SUBDIVISION PART LOT 112 DP 1073791
LYONS ROAD, NORTH BONVILLE
DEPARTMENT OF PLANNING MAJOR PROJECT M808-0080

UPDATED DETAILS

GS&P Drawing Set has been amended to incorporate requests of the various agencies.

The Drawing Set now contains Drawing 101 to 122. Refer to Appendix 4.

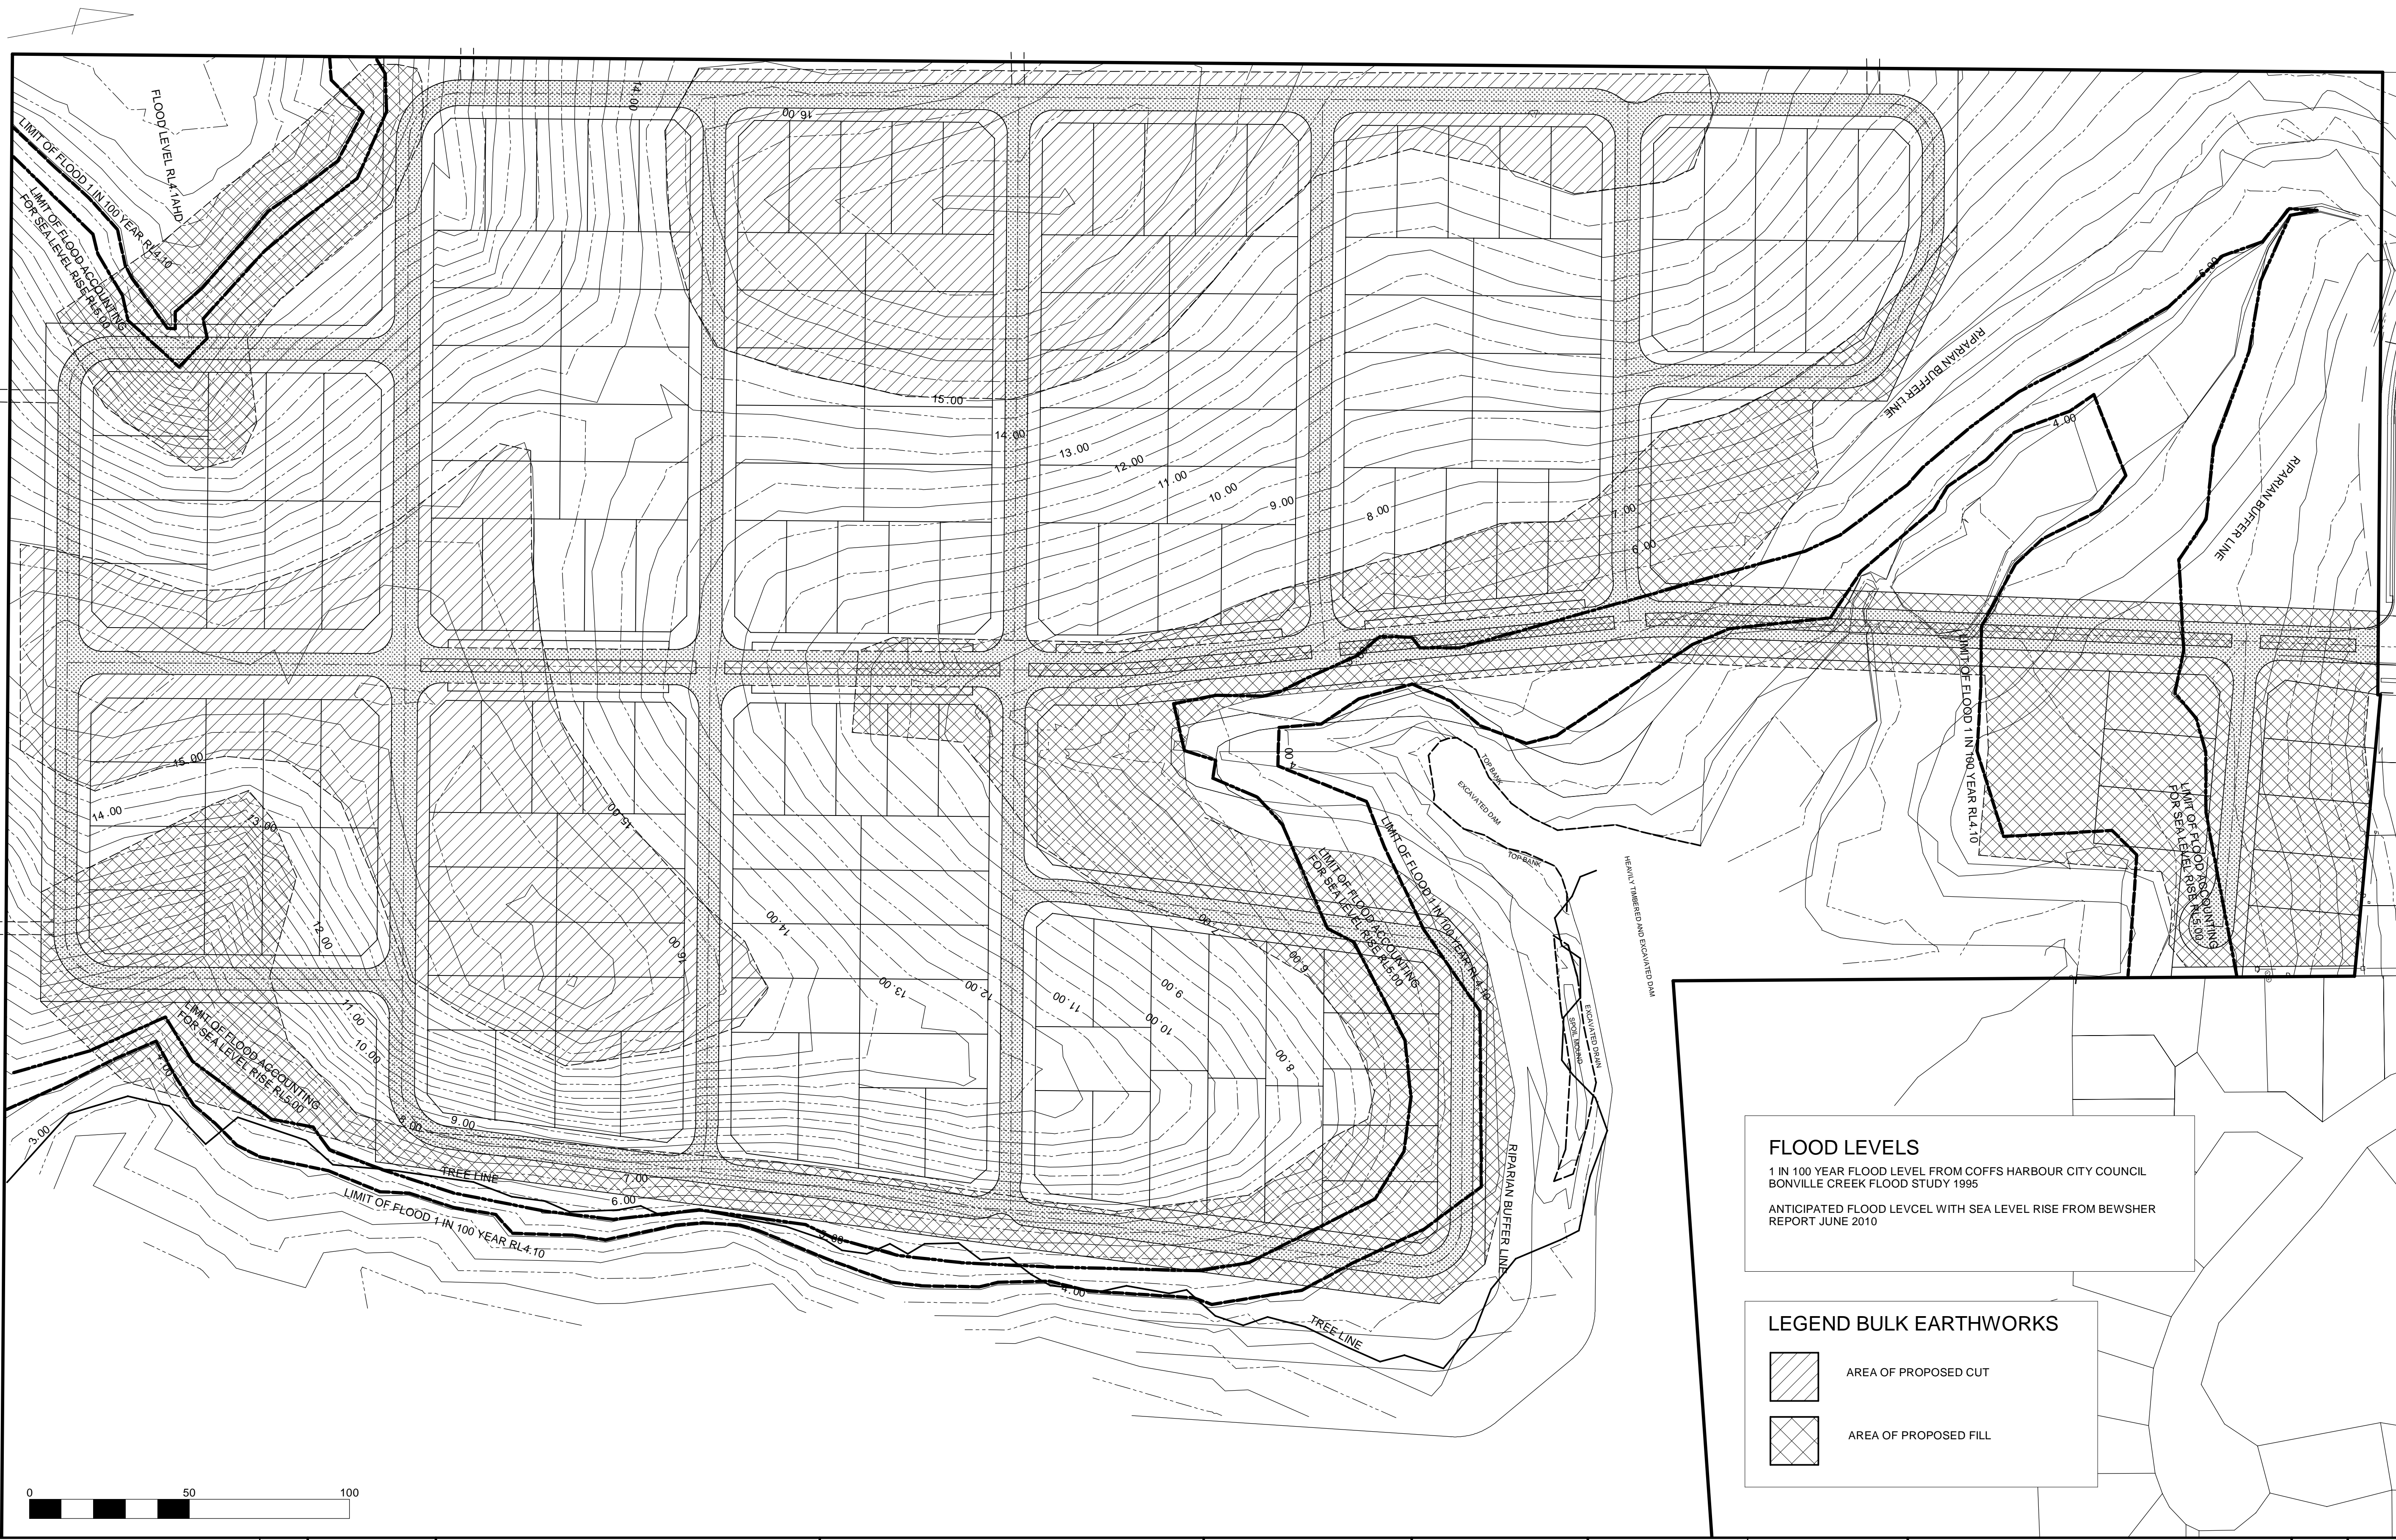
The project details contain proposals for the use of central swale drains in the main road as part of the WSUD treatment of stormwater.

Council has recently amended their WSUD policy such that central swale drains are excluded from the policy.

Due to the time constraints involved in a redesign of this issue Council has agreed that the Development Consent can be conditioned such that the WSUD design is modified by removal of the swale drains prior to submission of a Construction Certificate (C.C.) application.

Job No 0824 Drawing No 111B

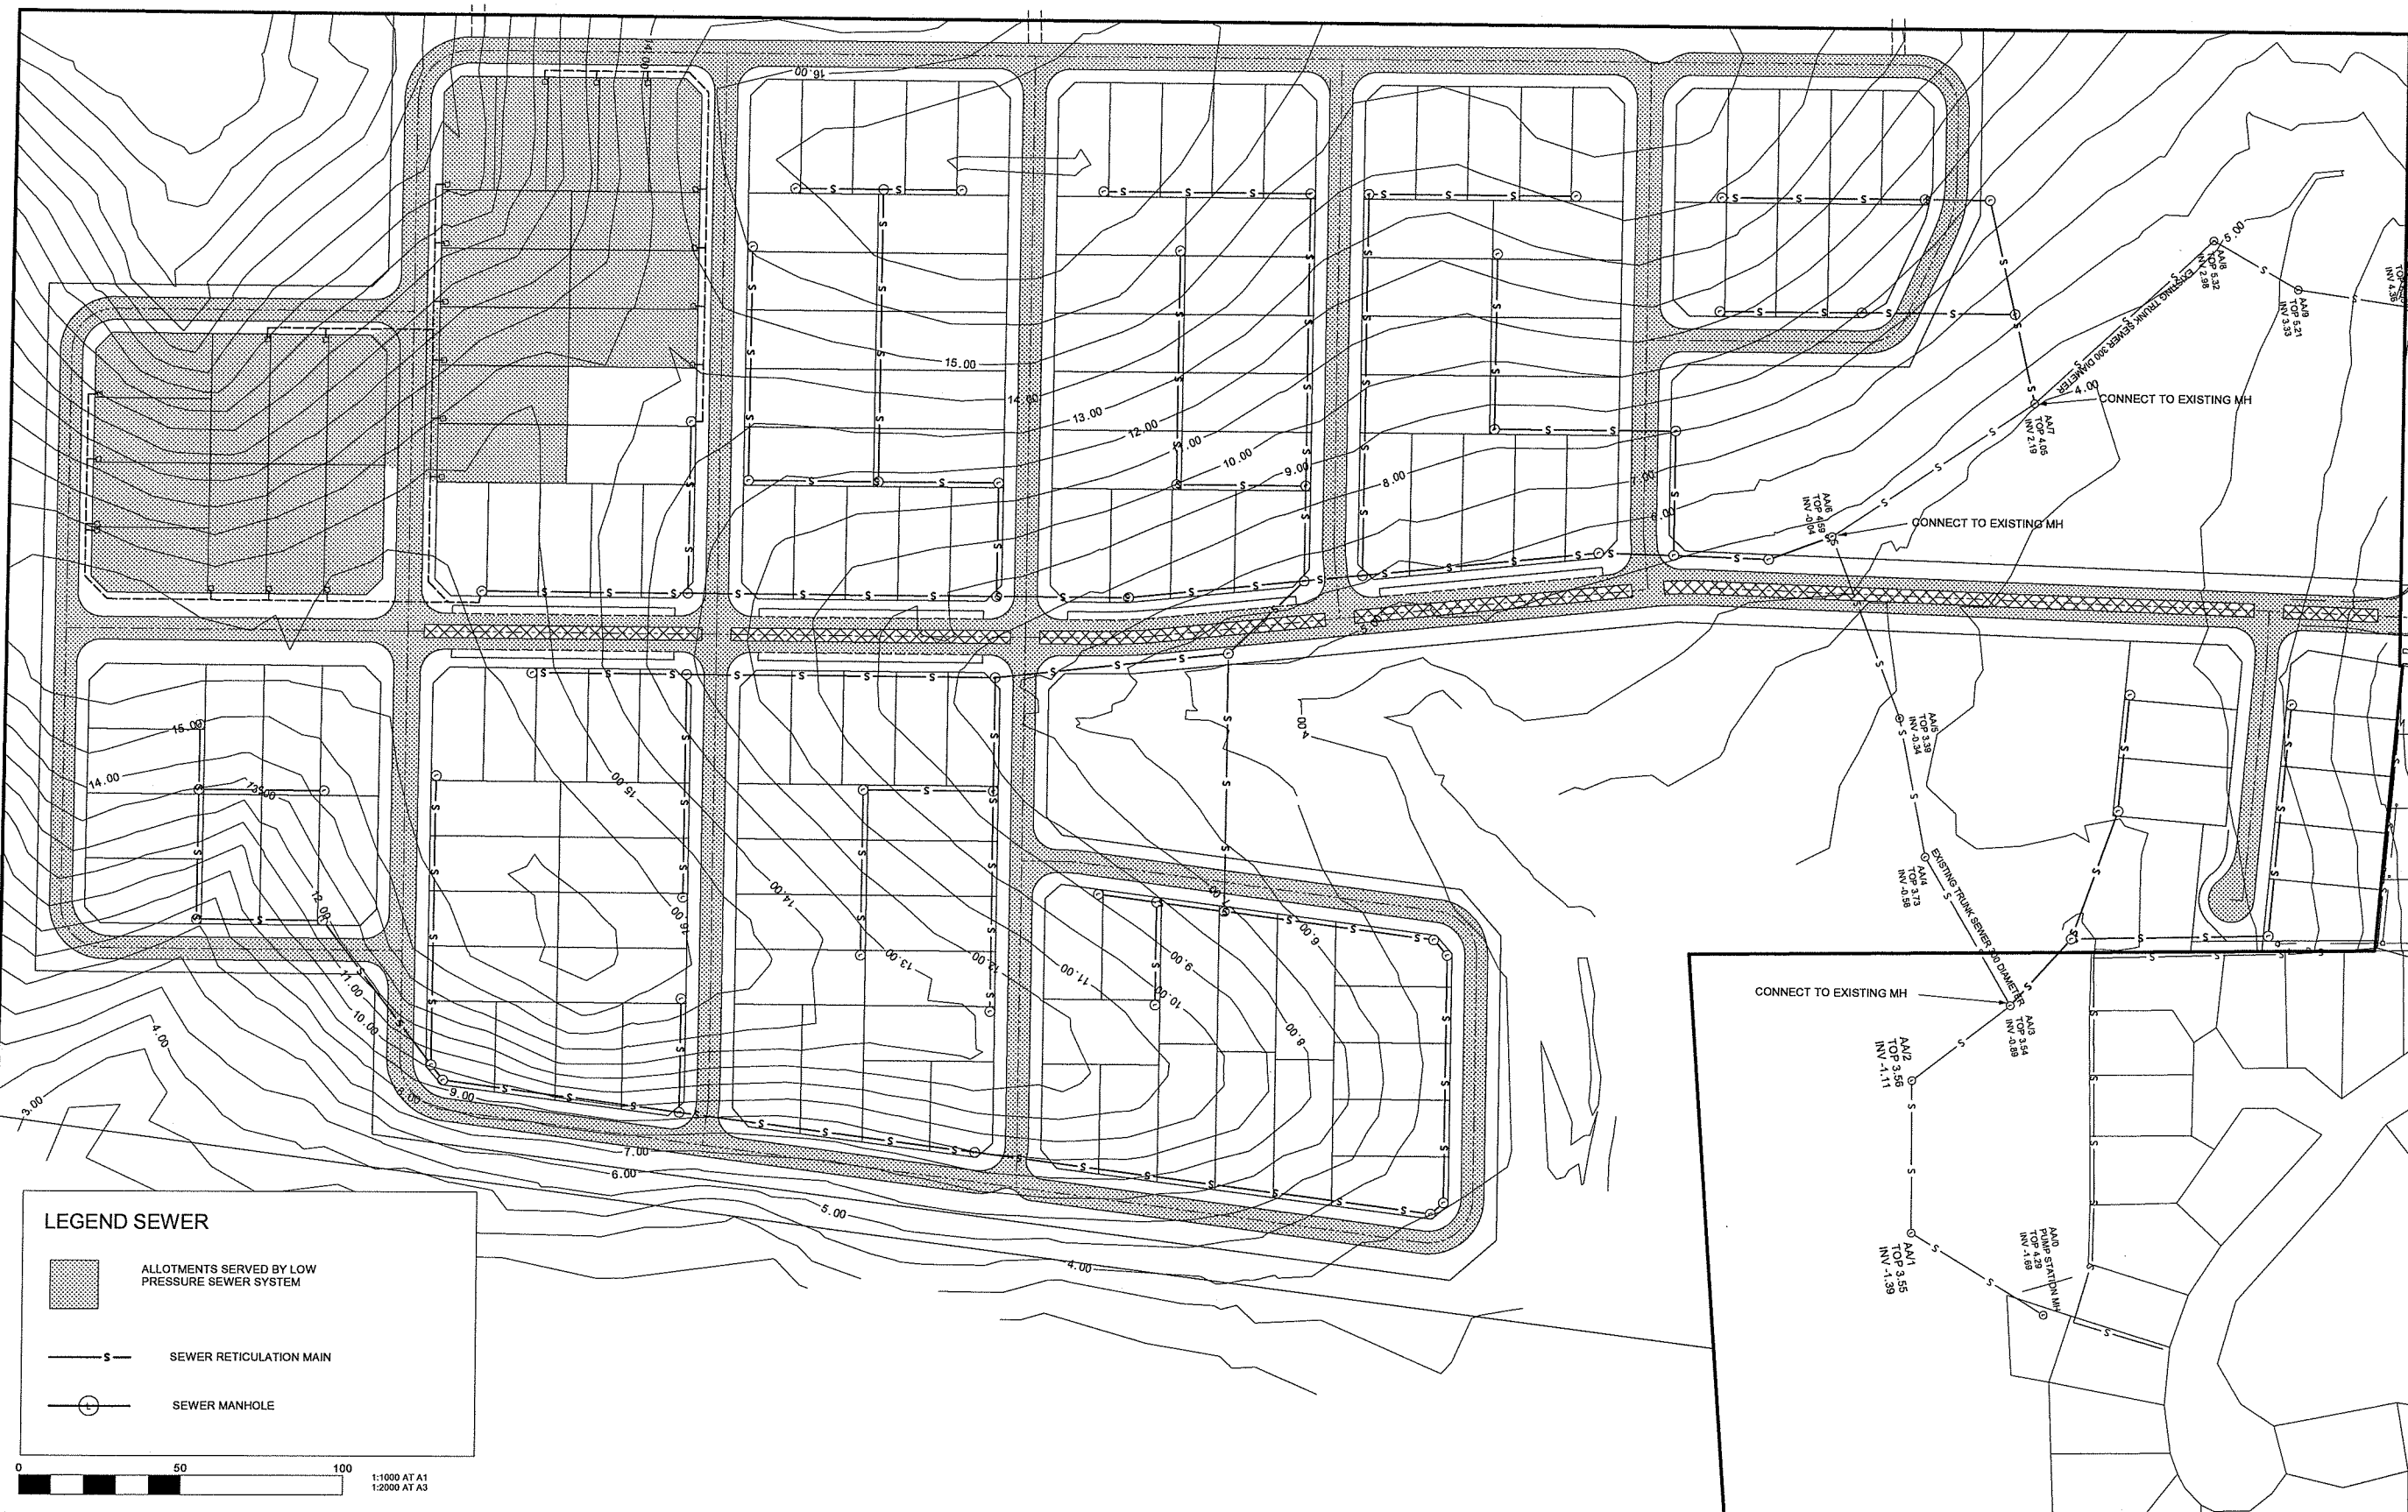
The original project details showed a small section of the development at the Southwest corner that required a small pump station to enable sewer.

Council has recently changed its sewer design policy to enable the use of a "low pressure" system.

The project drawings have been amended to show a low pressure system.
